Subject: highways comment

3/2013/0378 Main Street, Grindleton.

Please note I have no objection to this application, but please consider attaching the following condition and note to any consent you may decide to grant.

Proposed Site Plan
And West Elevation

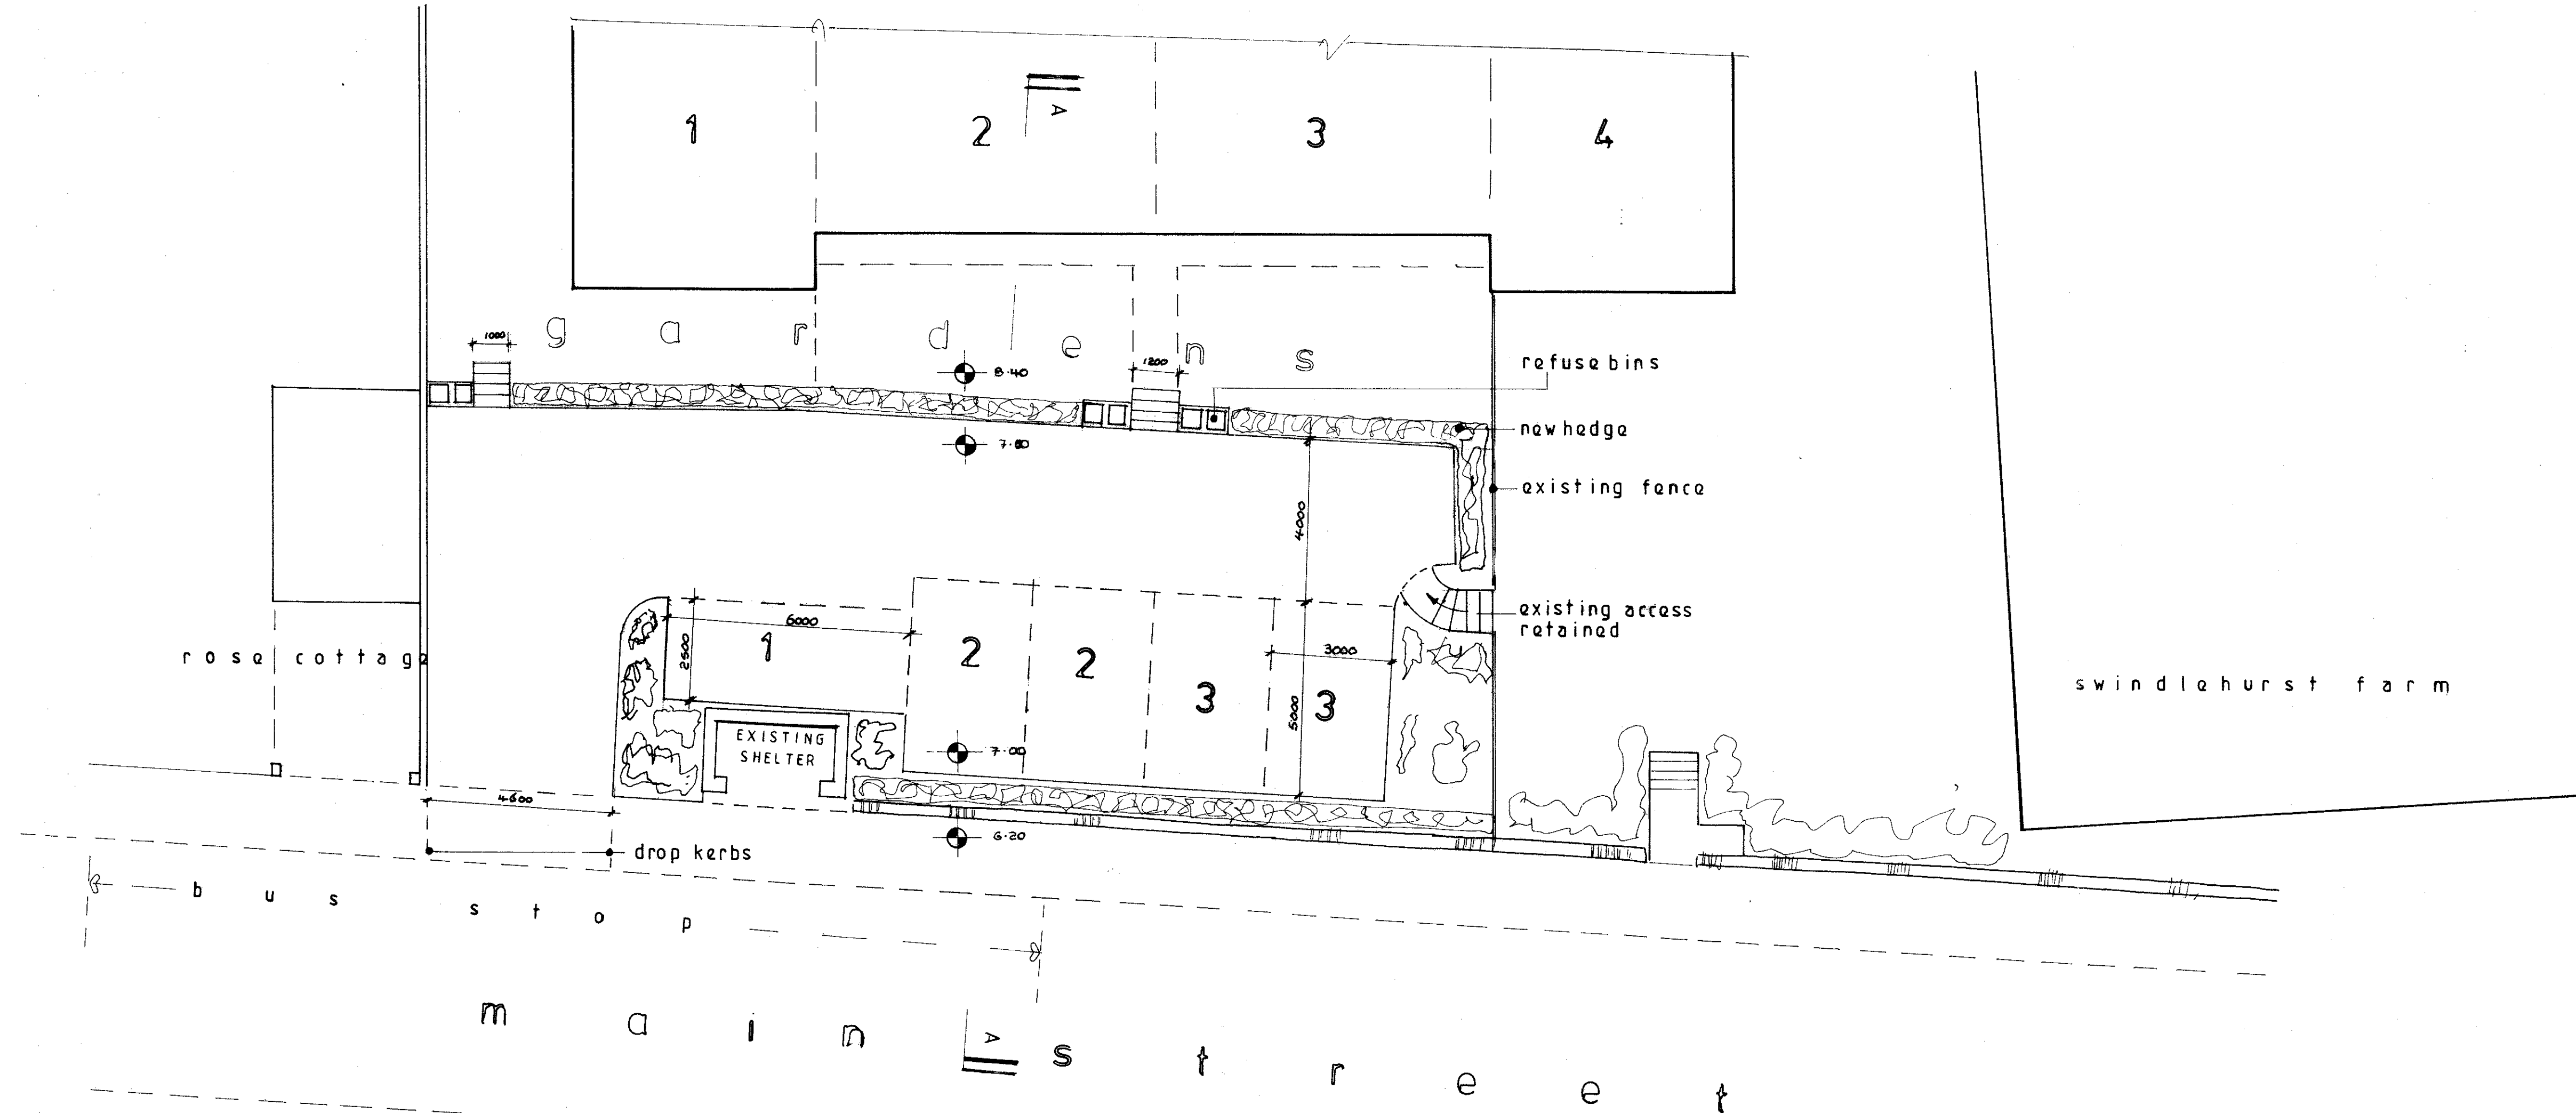
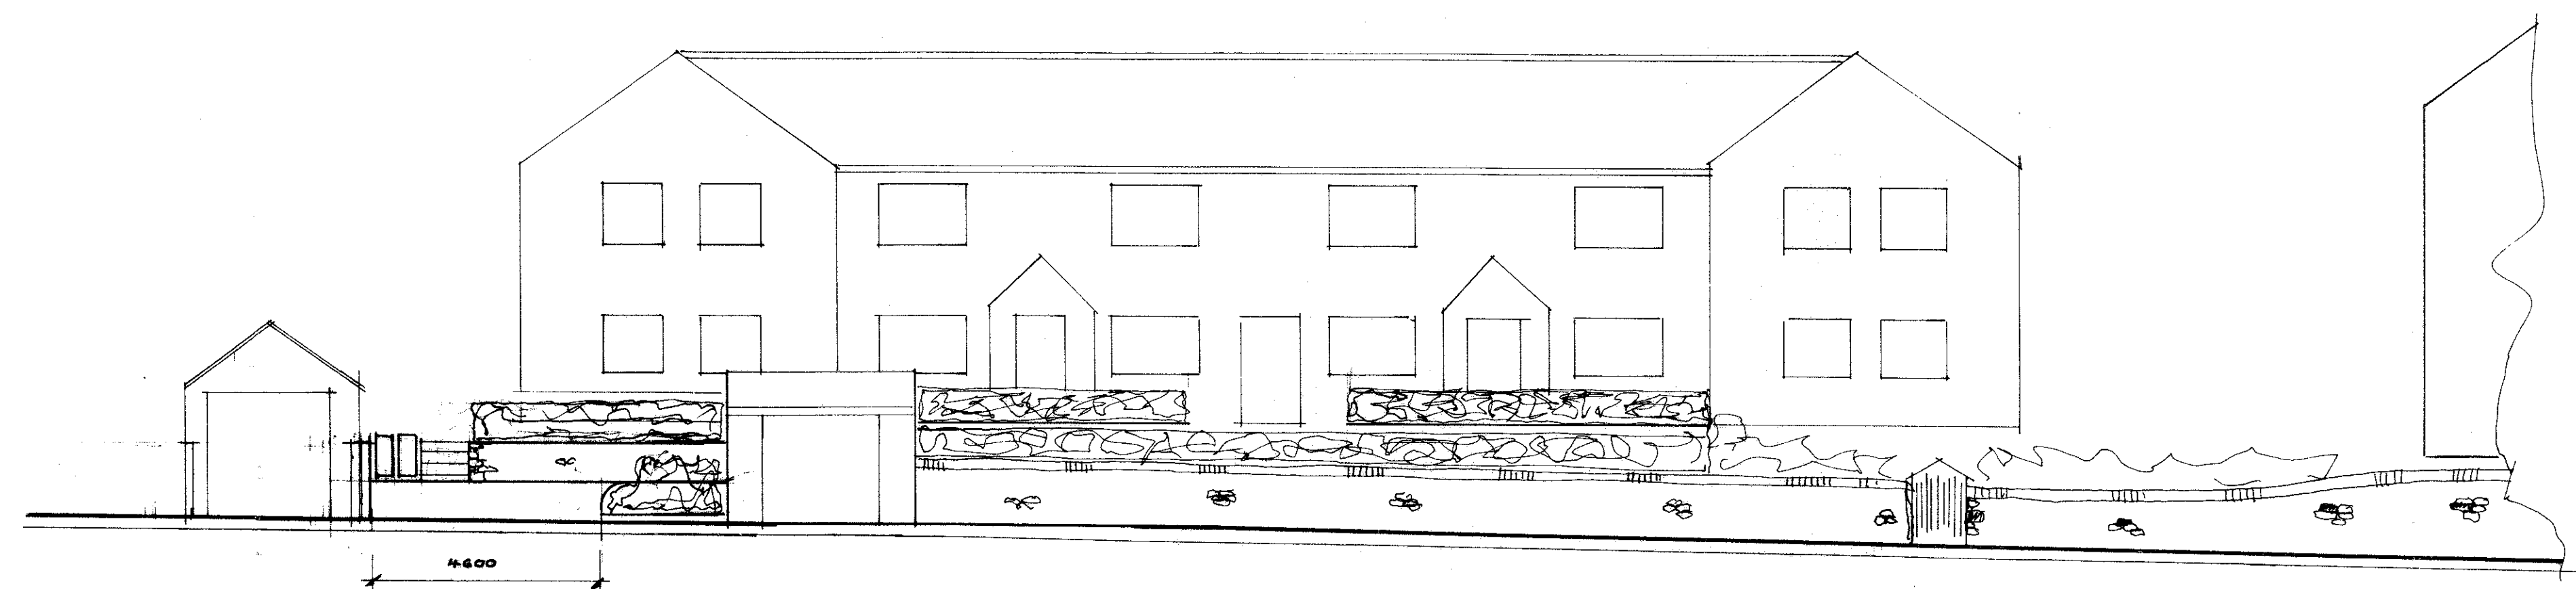
The layout of the development shall include provisions to enable vehicles to enter and leave the highway in forward gear and the vehicular turning space shall be laid out and be available for use before the development is brought into use. Reason: Vehicles reversing to and from the highway are a hazard to other road users.
